Outer Dowsing Offshore Wind Farm

Appendix C7 to the Natural England Deadline 6 Submission
Natural England's Advice on Benthic Ecology

Planning Inspectorate Reference EN010130

4th April 2025

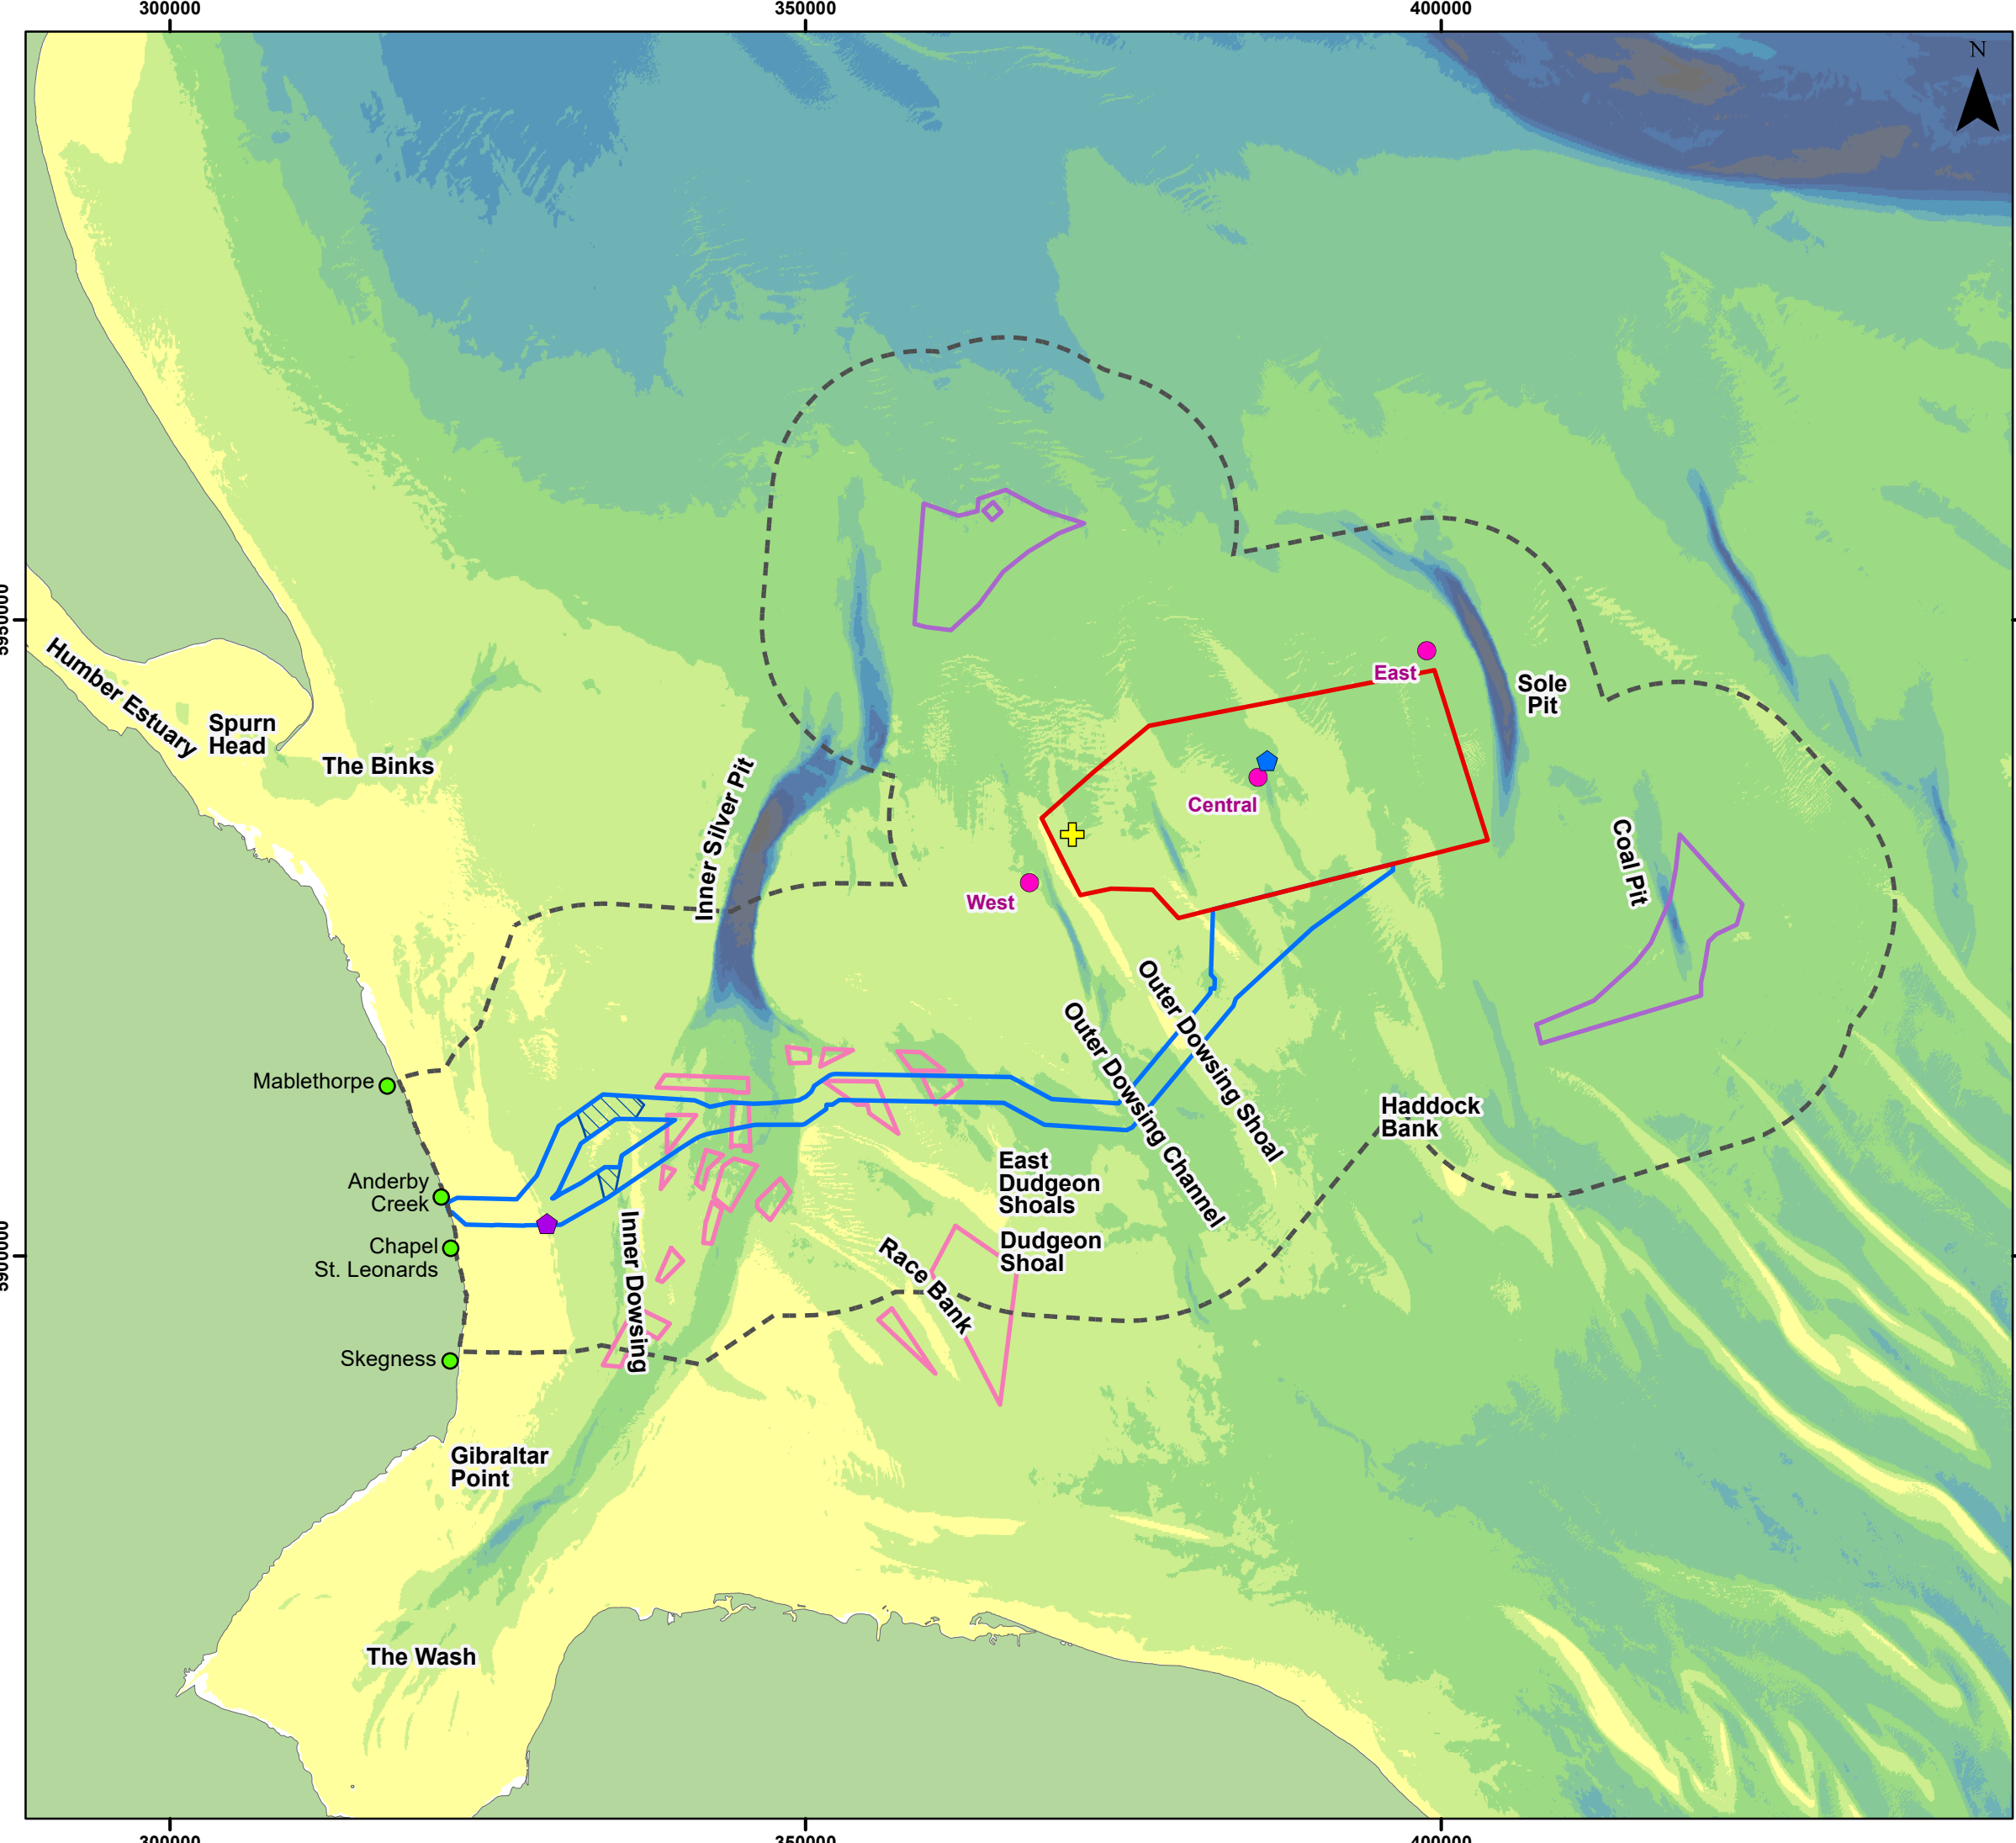
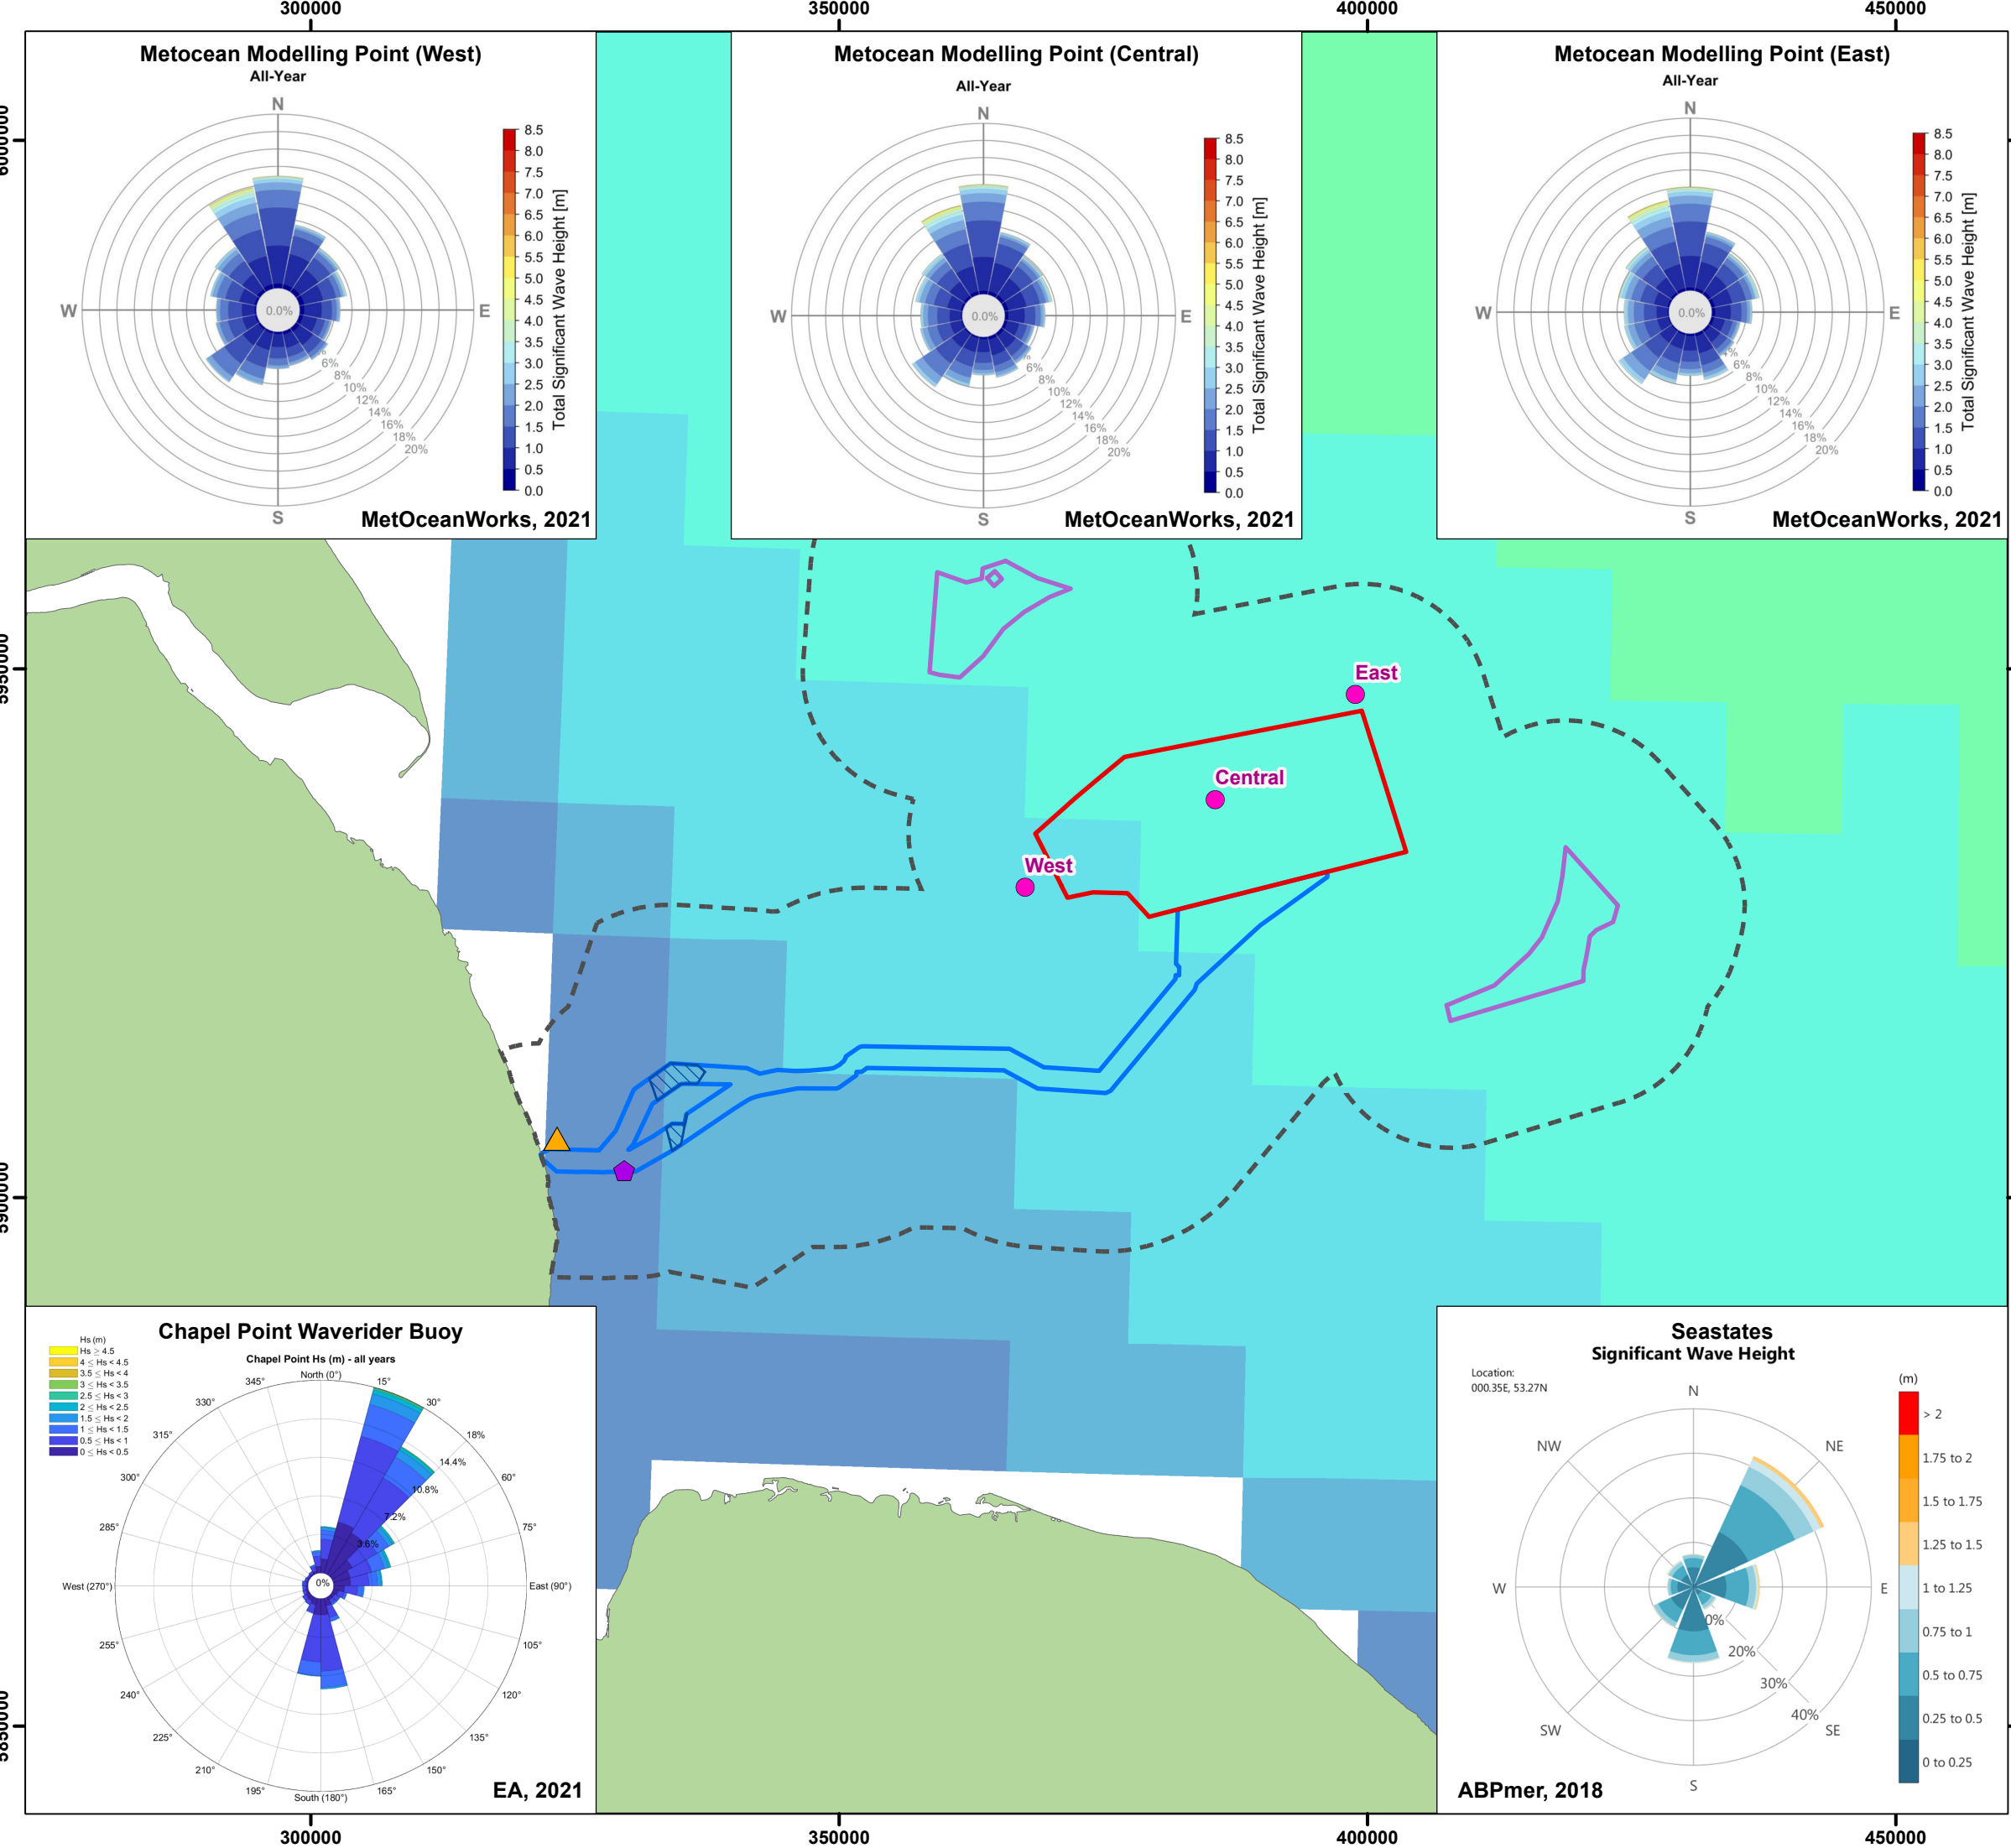
- 1. NE previous advice: Table 2, optional parameter 1 – It is not clear if this parameter has considered dominant direction tidal flows which would require an increase in the buffer from 2km to 3km. The figures in ‘Chapter 7 Marine Physical Processes Figures Part 1 of 2’ demonstrate that the dominant tidal flows and bedload transport across the ECC are in the NNW and SSW directions, and as such, we advise that the 2km buffers applied should be extended to 3km to align with the description of optional parameter 1 within the Technical Note.**

ODOW response: The Applicant notes difficulty in interpreting ‘Optional parameter 1,’ specifically the phrasing: “*within 2 km of sandbanks in any direction OR within 3km in the direction of tidal stream, whichever is the greater* 2.” Our initial interpretation was that the worst-case area for the majority of the Offshore ECC was ‘within a 2 km radius of the sandbanks’. This interpretation arose due to the direction of the tidal stream (approximately NW-SE/ N-S, see Figure below which presents tidal ellipses), we therefore did not anticipate that this would have a greater impact on the width of the corridor than the 2 km buffer applied around the entire sandbank.

Furthermore, there was additional confusion surrounding the phrase “OR within 3km in the direction of tidal stream,” as it does not clearly state what the 3km buffer is associated in relation to the tidal stream – we assume that this would be the northern points of the sandbanks for the current features of interest. We have mapped the tidal ellipse data (see figure below), which demonstrates that a 3 km buffer could be applied to the north of the sandbank features, specifically “in the direction of tidal stream.” This would result in two small areas highlighted by the red cross hatch in the figure below being included as supporting habitat. This additional area is 2.5km². As illustrated in the figure, no other additional adjustments in relation to ‘Optional parameter 1’ are necessary.

Natural England welcomes the addition of the 3km buffer to the north of the sandbank features. While this satisfies our previous advice; to ensure joint understanding of the approach, we highlight that according to the methods outlined within the Applicants [*Sabellaria spinulosa* reef supporting habitat Technical Note: February 2025], much of the red cross hatch area which we have annotated with number ‘1’ below should have been already included as supporting habitat owing to the presence of the ‘SS.SBR.PoR.SspiMx - *Sabellaria spinulosa* on stable circalittoral mixed sediment’ which has been mapped in that location (in alignment with optional parameters 2 and 4).
